Recommendation Report for Planning Permission for Works or Extension to a Dwelling

REF NO: BR/48/20/HH

LOCATION: 12 Cavendish Road
Bognor Regis
PO21 2JW

PROPOSAL: Two storey and single storey rear chalet extension

sheet 1 a of 3

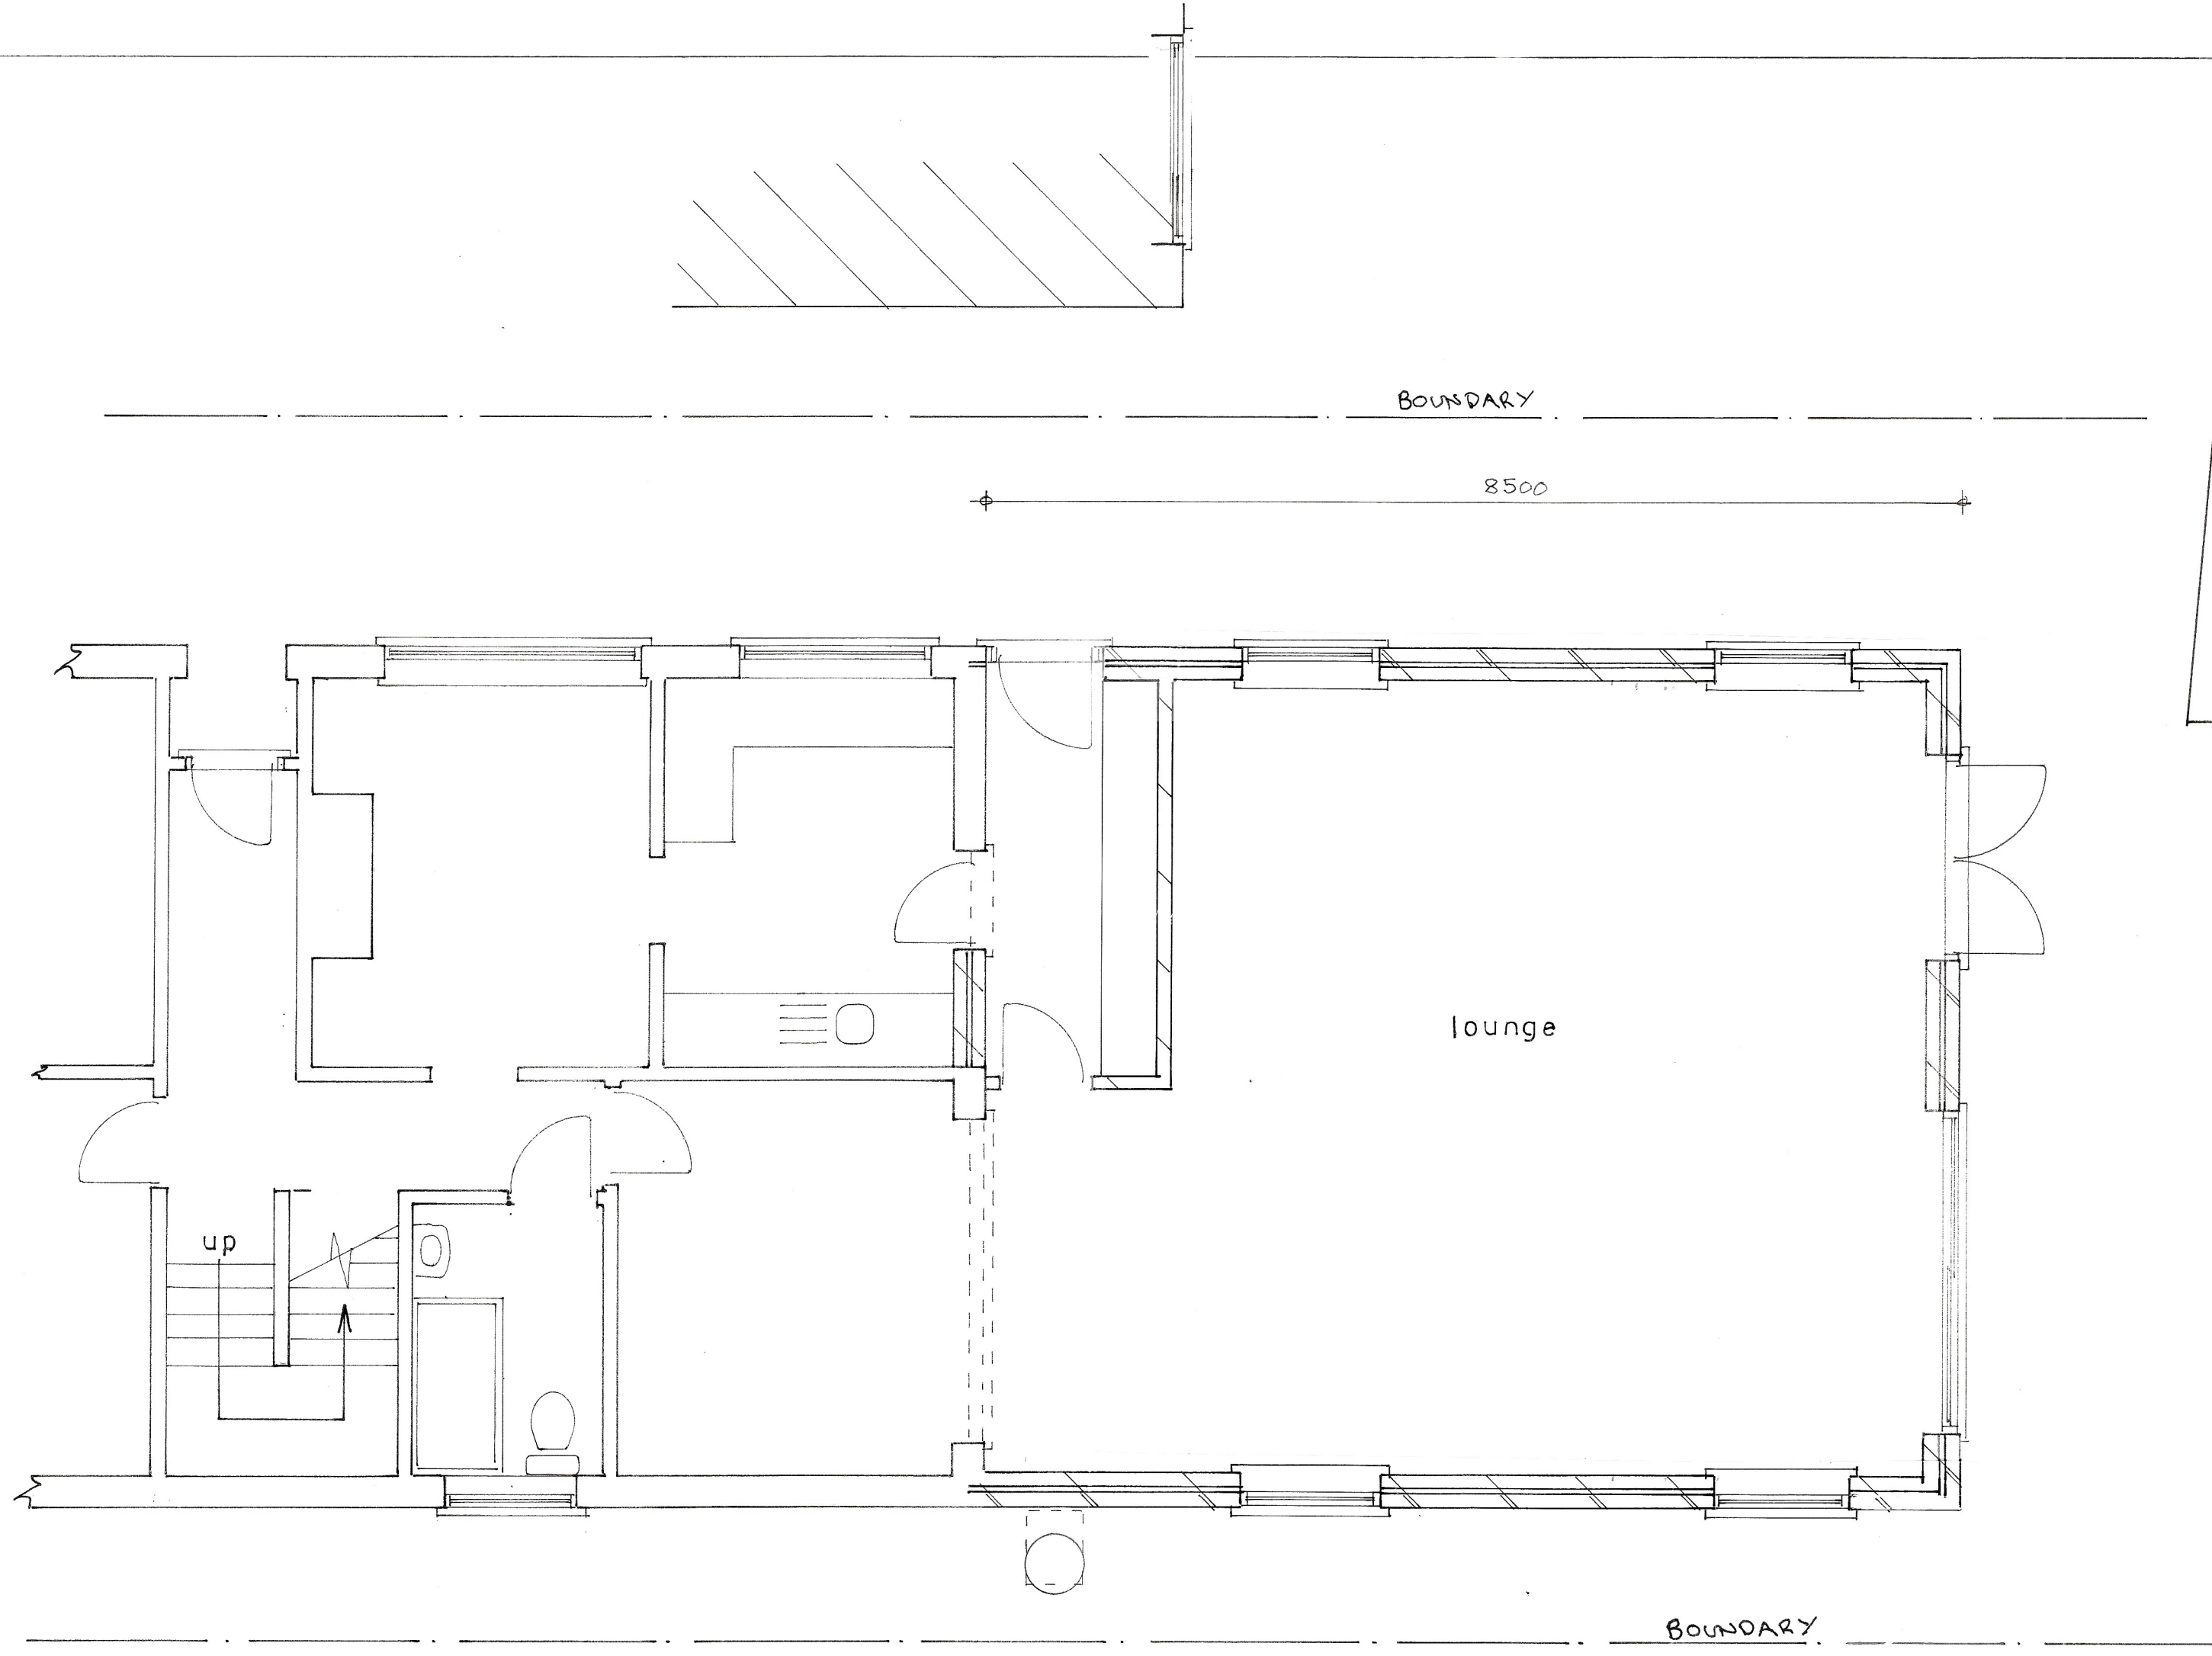
There will be additional windows to the ground floor although due to their siting, views will be impeded by boundary fencing. There will be 1 additional velux to the western elevation however due to its height above finished floor level is not considered to result in adverse overlooking.

sheet 2 a of 3

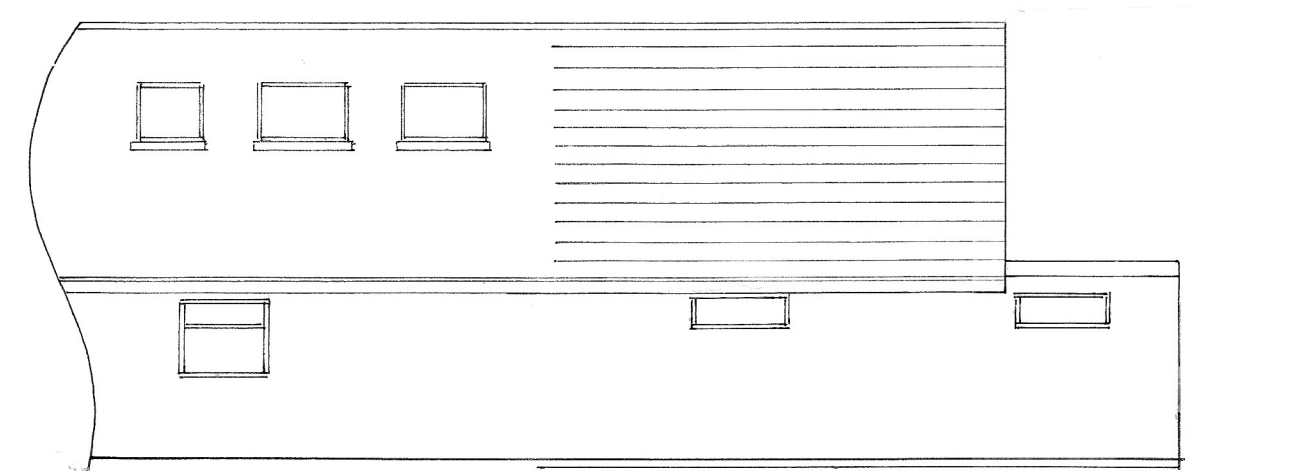
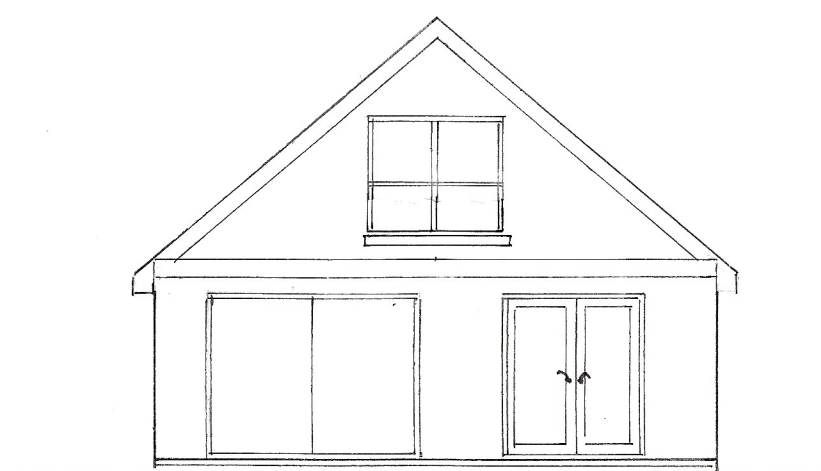
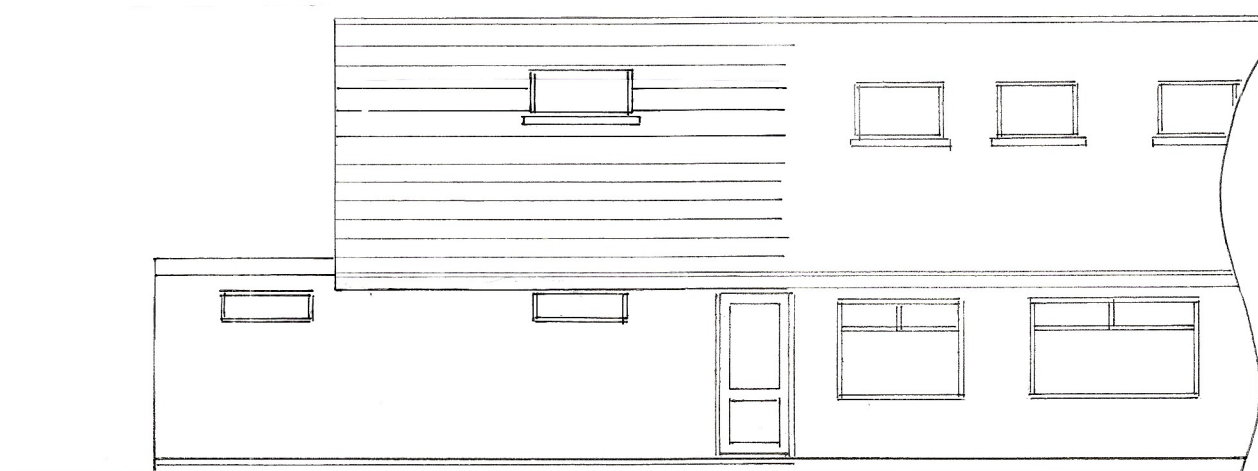
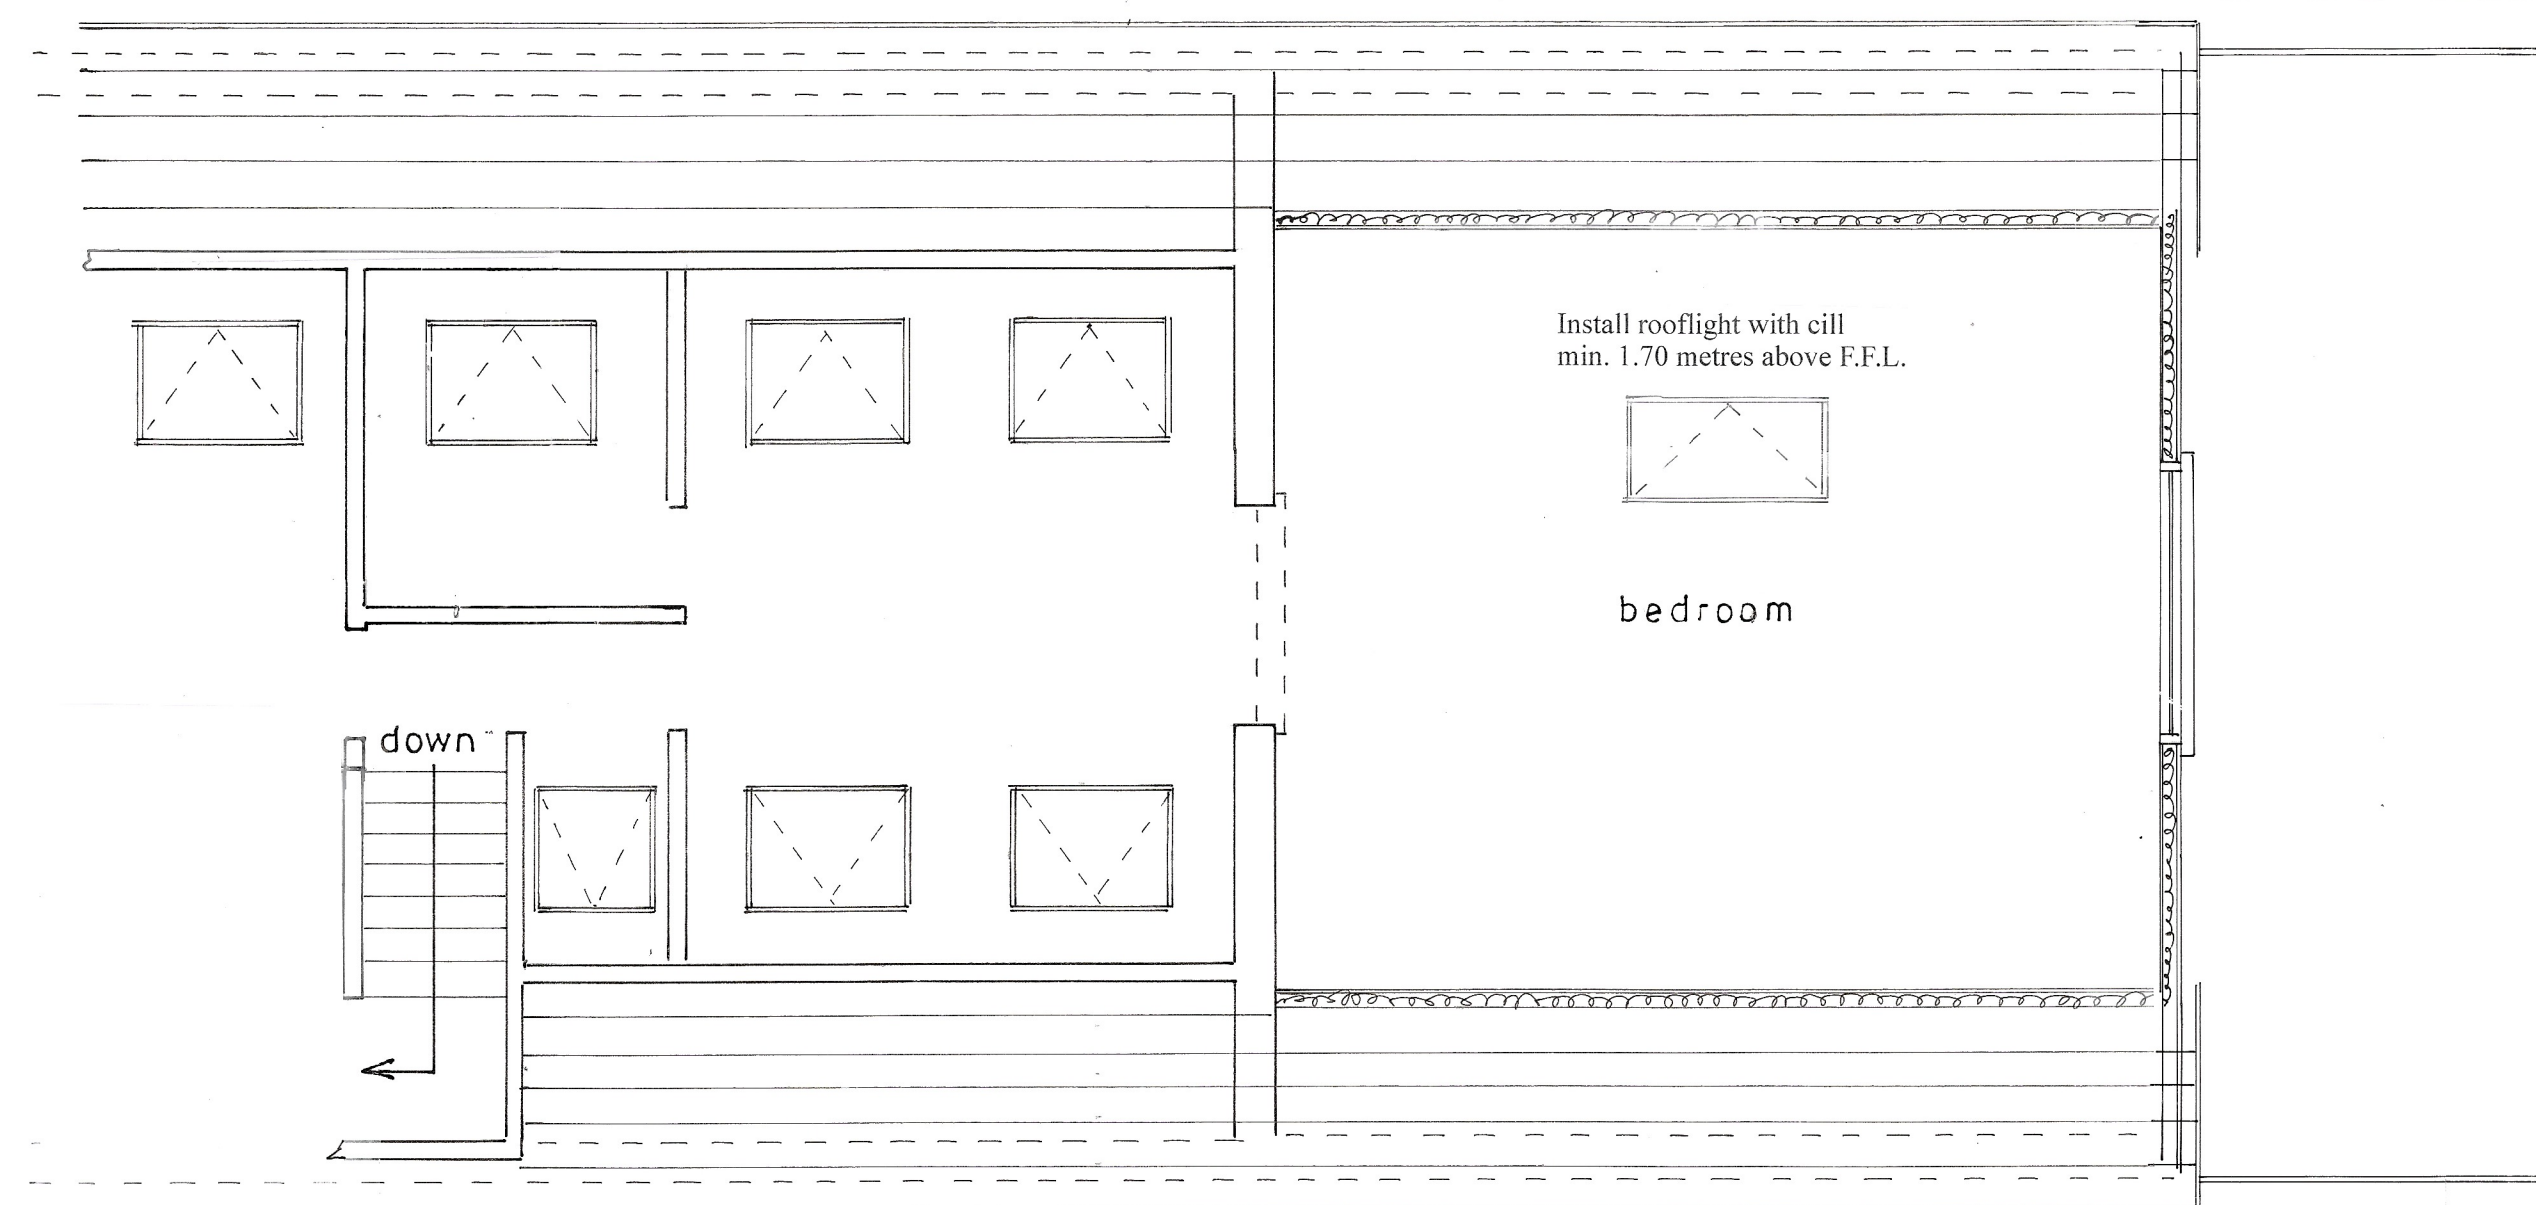
The extension will have a total depth of 8.5m. This will form 6m at two storey which will have a maximum height of 6m meeting with the existing ridge and eaves height of the host dwelling. The height will then reduce to single storey with height of 2.85m with a further depth of around 2.5m.

The extension extends beyond the rear to the eastern side at No.10,however the majority of this will be at single storey with around 1.75m at two storey and 2.5m at single storey. There is a set of doors to the rear ground floor neighbouring property which the extension may intersect when a 45 degree angle is drawn from the centre. However this would intersect the single storey element and with 1.15m separation and sufficient boundary fencing, the addition is not deemed to result in an adverse impact.

To the western side, the extension does extend around 6.5m beyond the rear of No.14 with 4m at two storey. Whilst this is likely to give rise to an overbearing impact as a result of the depth, there is approximately 1.95m retained to the boundary and with the height reducing to single storey, it is not
